Ribble Valley Borough Council
By email

Your ref 3/2026/0313
Our ref DC/26/1421
Date 17-JUN-26

Location: Springwood Drive Whalley BB7 9XL Phase 2 Lawsonsteads
Proposal: Approval of details reserved by conditions 15 (water mains protection) on planning permission 3/2021/0760.

Further to our review of the submitted information, United Utilities does not feel sufficient information has been provided at this time, therefore we recommend that Condition 15 is **NOT discharged**.

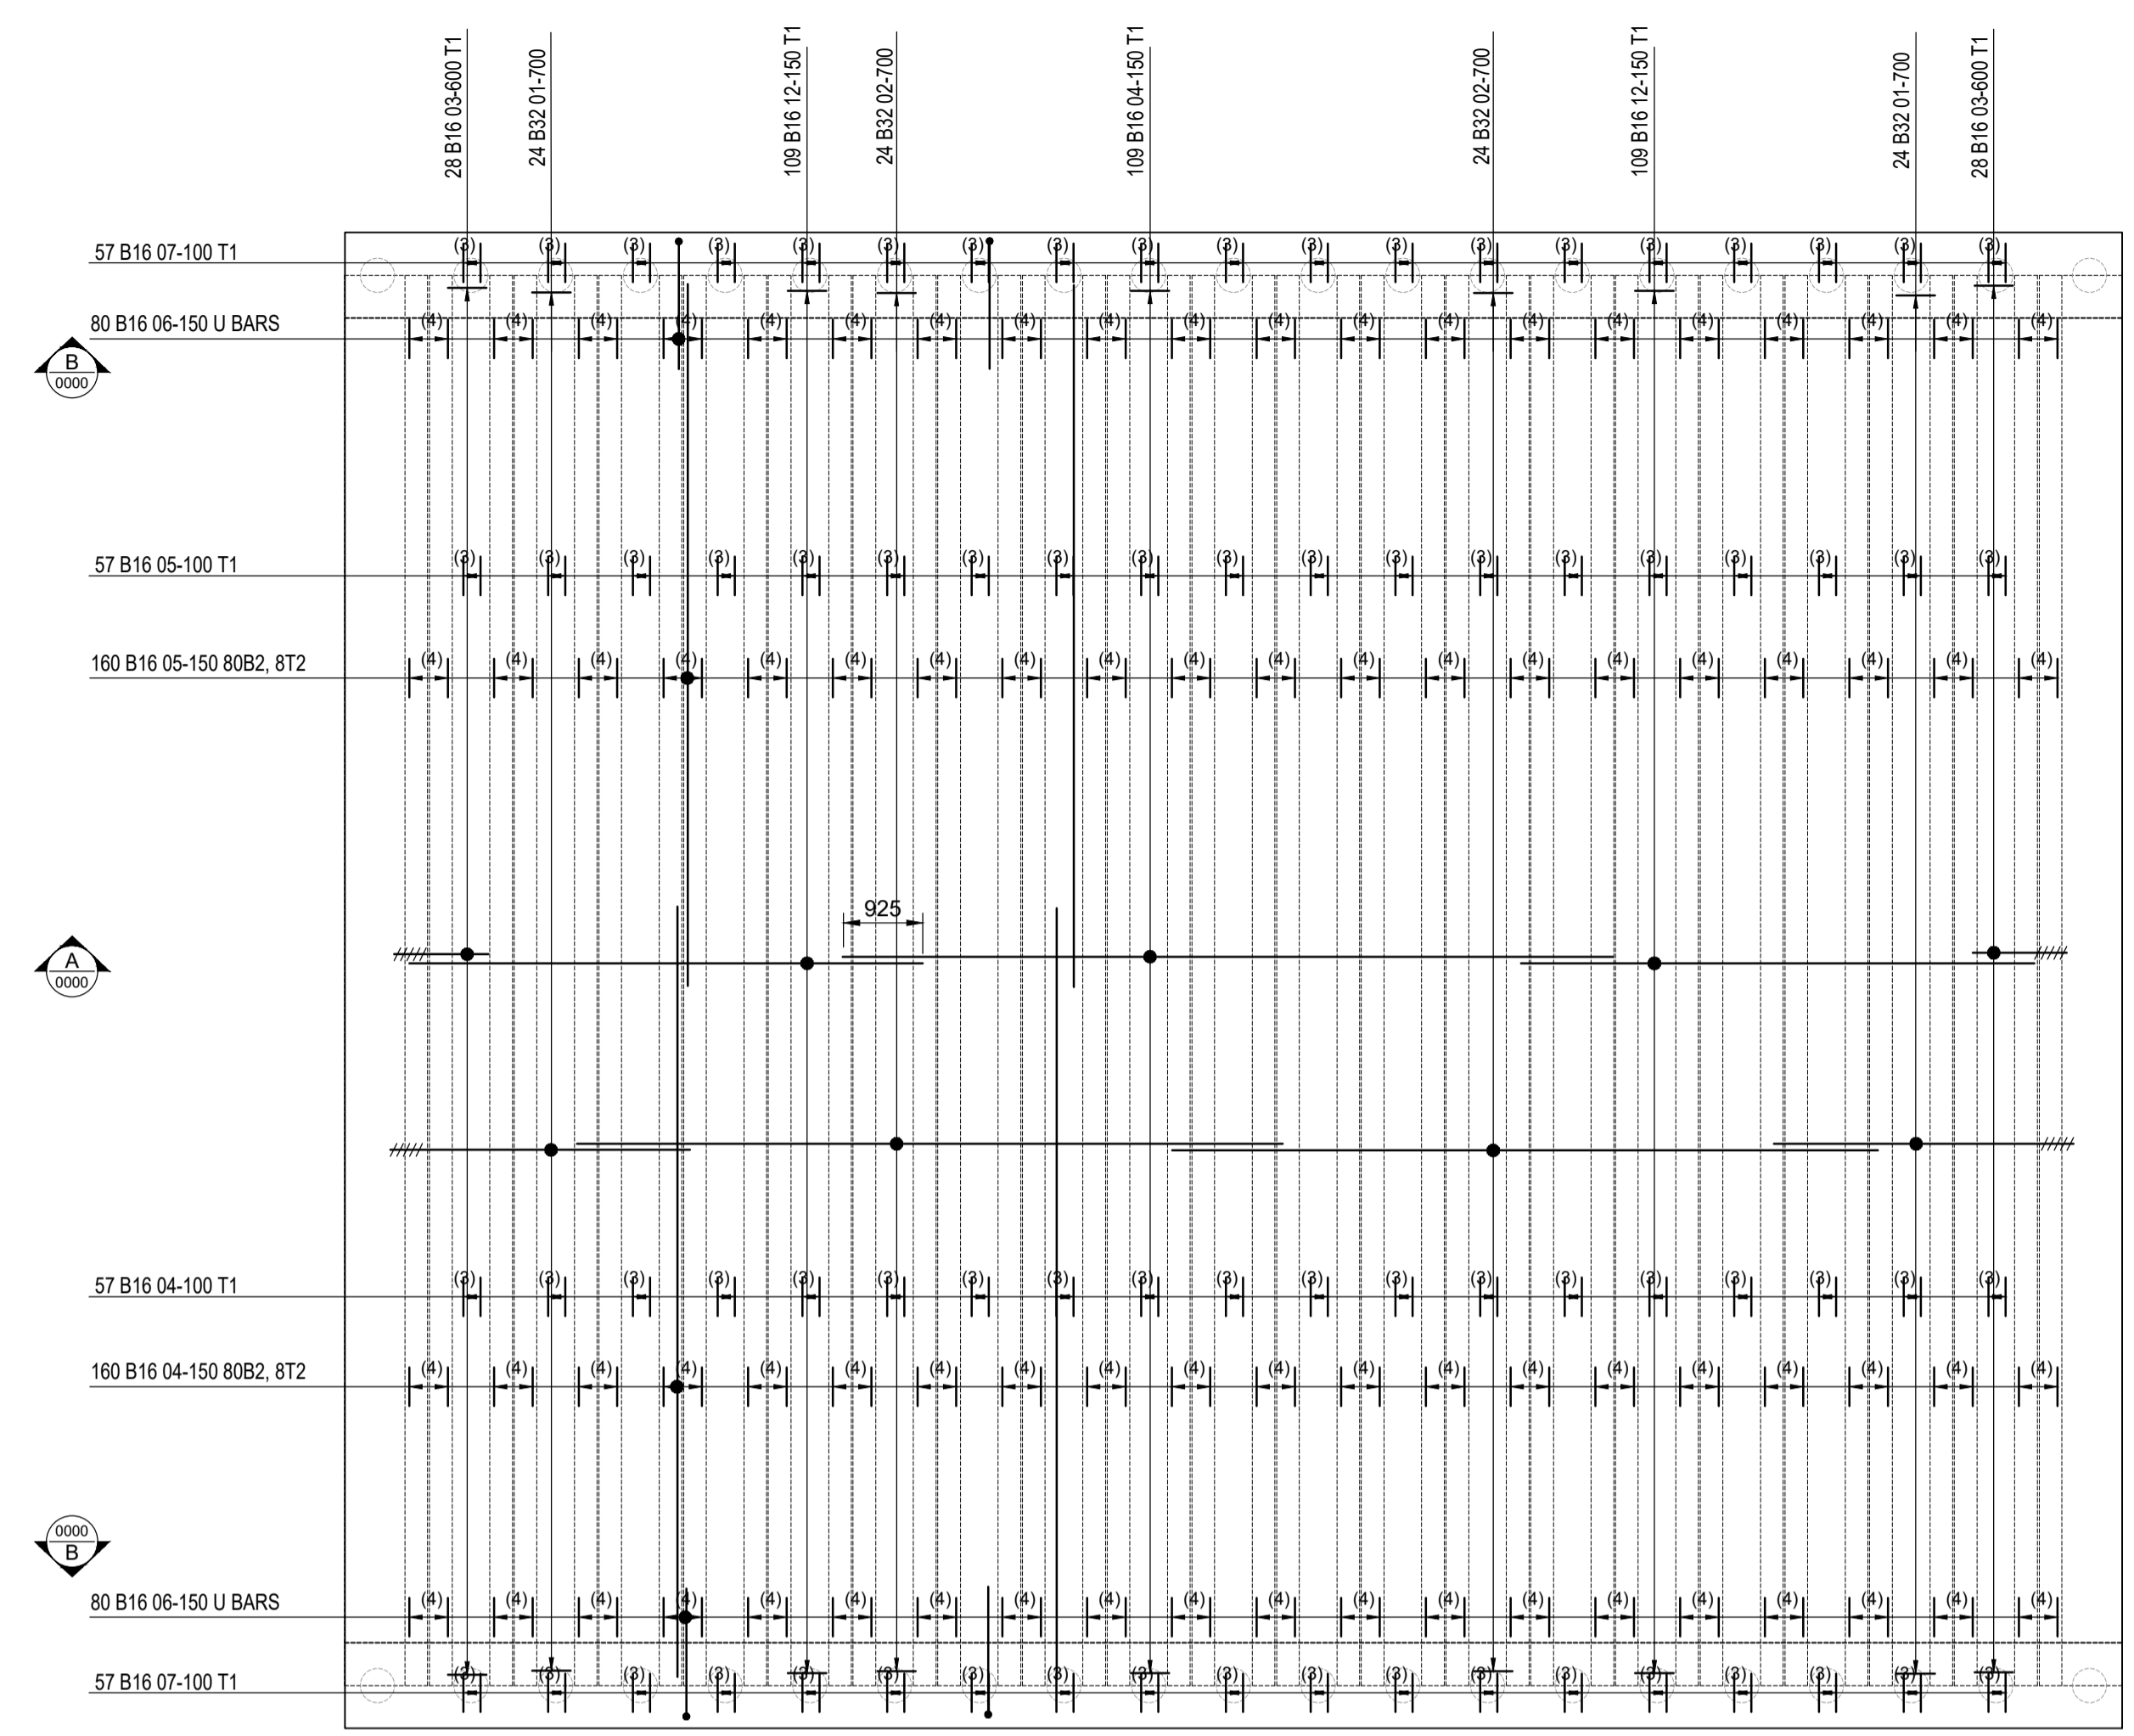
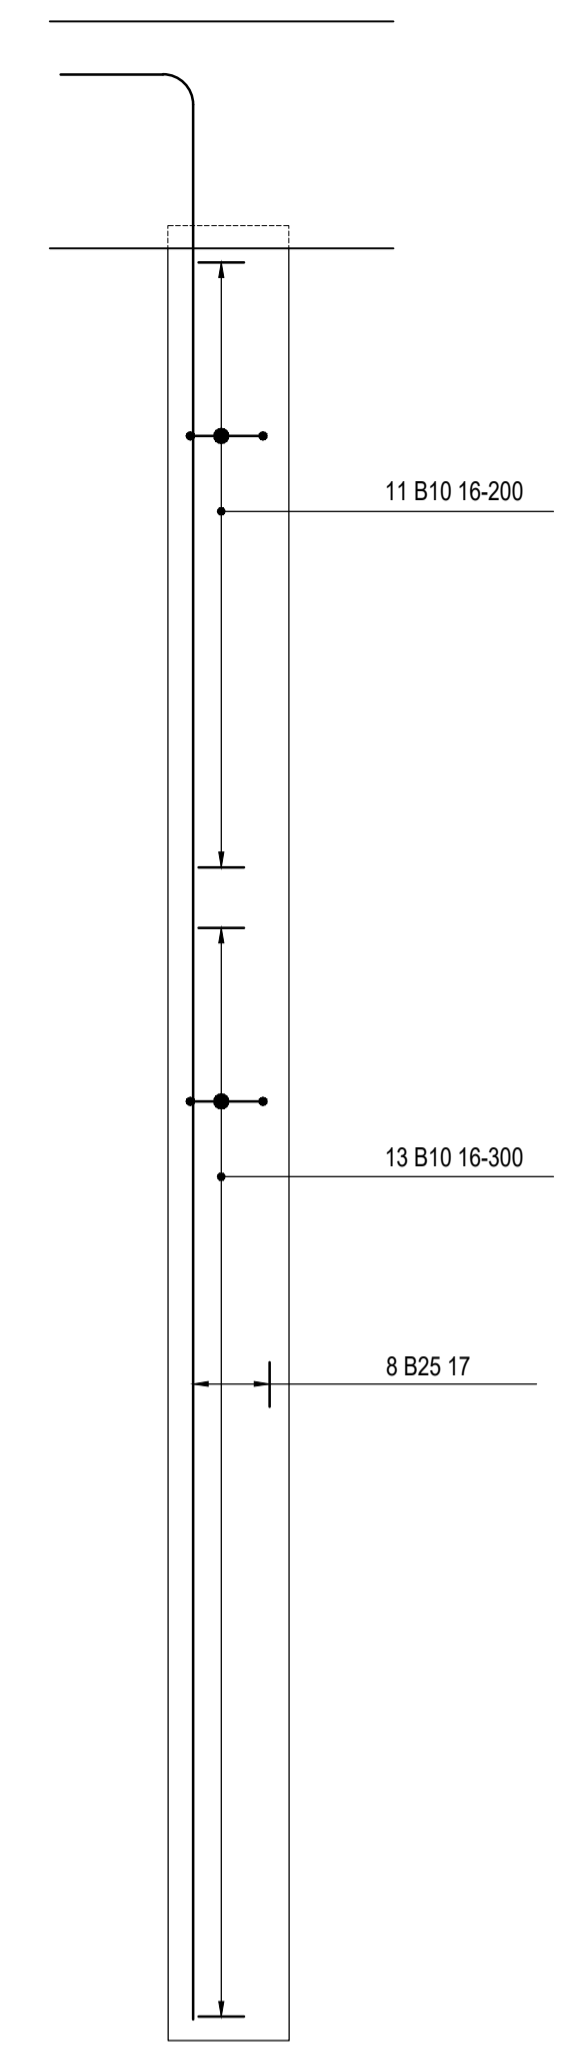
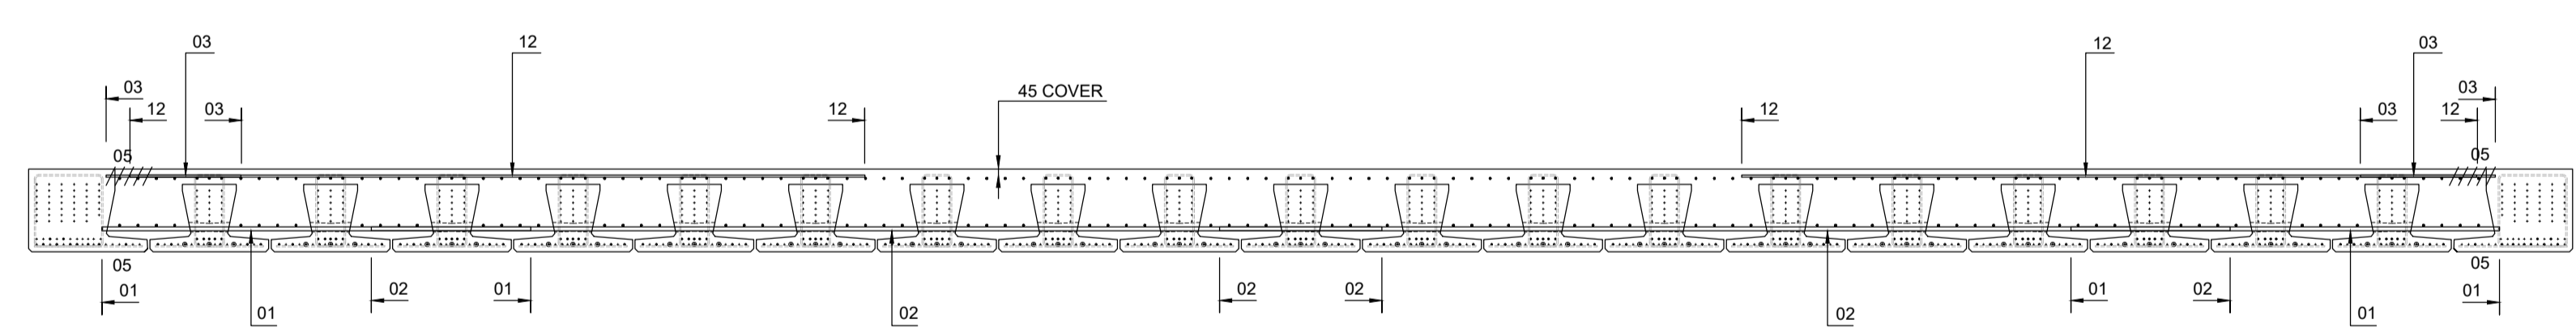
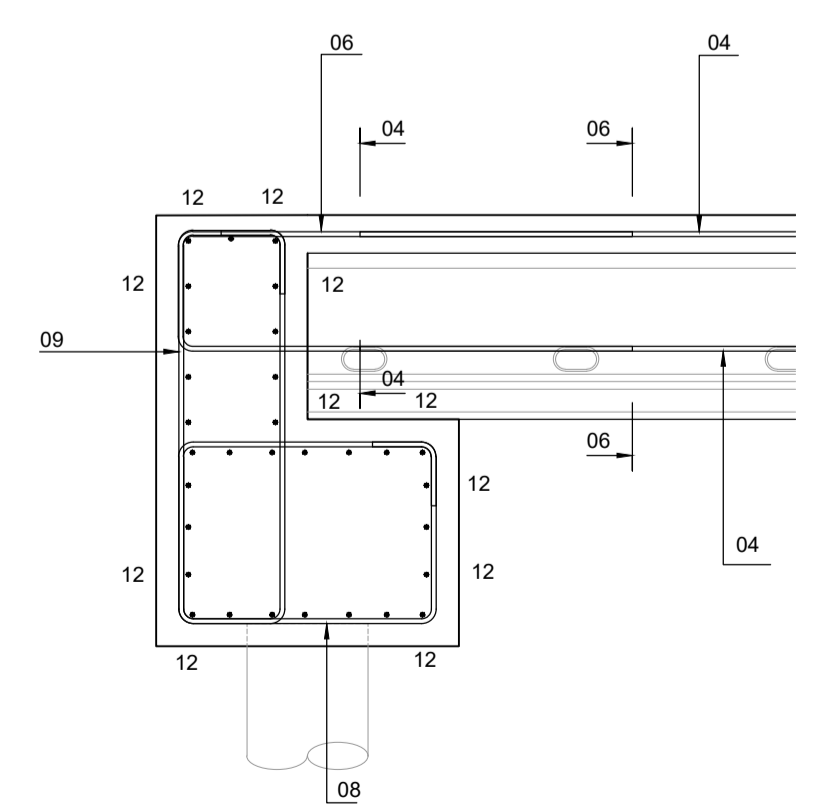
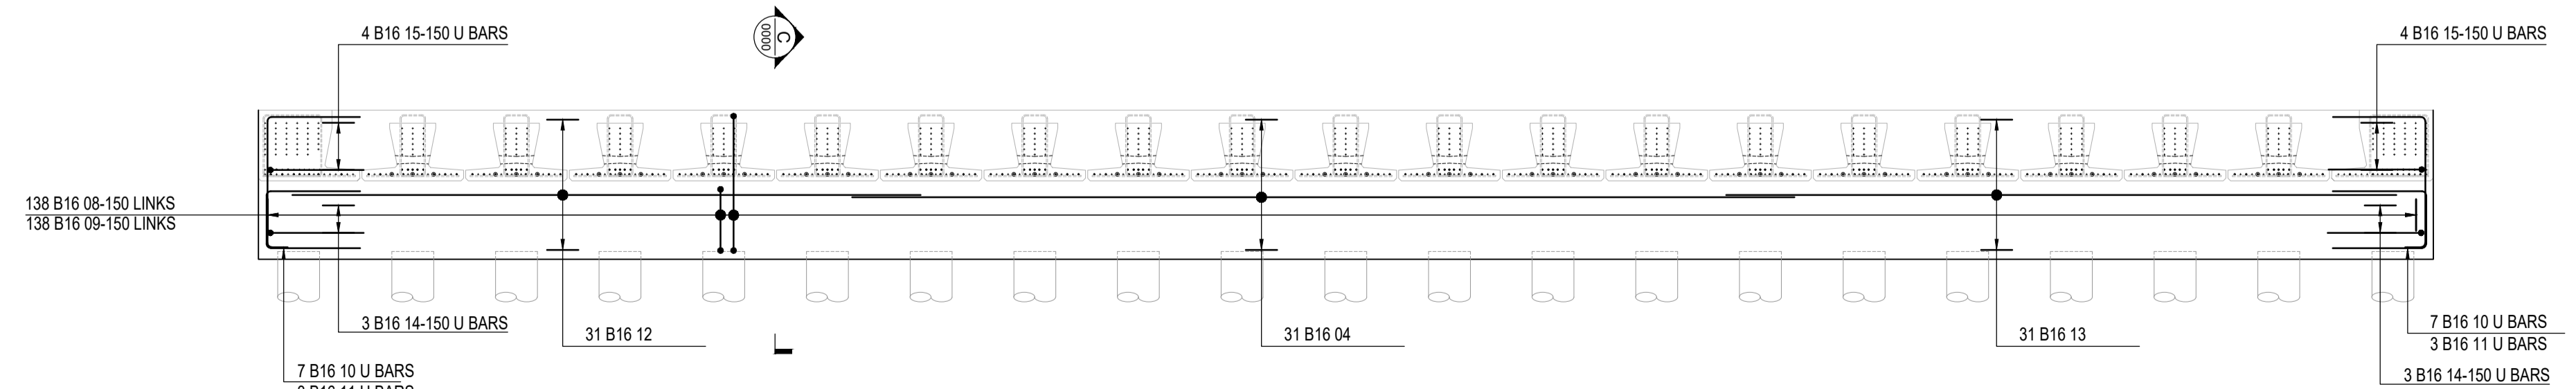
- *The temporary protection measures and the loading pressures underneath the pad;*
- *evidence that the ovality/deflection and buckling stability of the steel is within allowable limits set out in BS9295. In addition, the equivalent analysis for the rigid pipe / concrete main as per BS9295; and*
- *modelling of the soil stresses and ground settlement.*
